PORTLAND MAINE

October 6, 2010

Re: 192 Seashore Avenue, Peaks Island – 085 S015 – IR-2 – illegal ramp

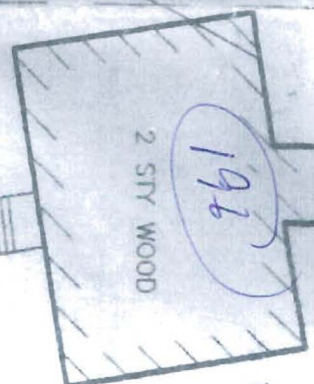
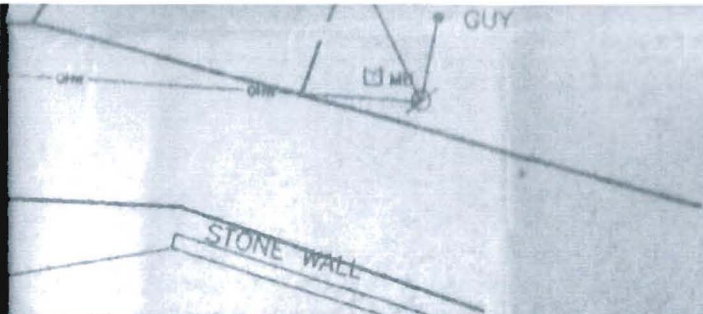
192 Island Avenue, Peaks Island is located in the I-R2 residential zone. The ramp needs to meet the zoning requirements. The one requirement that it does not appear to meet is the front yard setback. The minimum required front yard setback is twenty-five feet, except that the front yard does not need to exceed the average depth of the front yards on either side of the property [section 14-145.11(c)(1)]. The ramp is not located twenty-five feet from the front property line. You need to submit information that shows what the front setbacks are for the abutting properties to show what the average is. If the ramp meets the average setback, then just apply to permit it. If it doesn't meet the average setback, then you will need to remove it and submit a permit that shows how the porch will be accessed from grade.
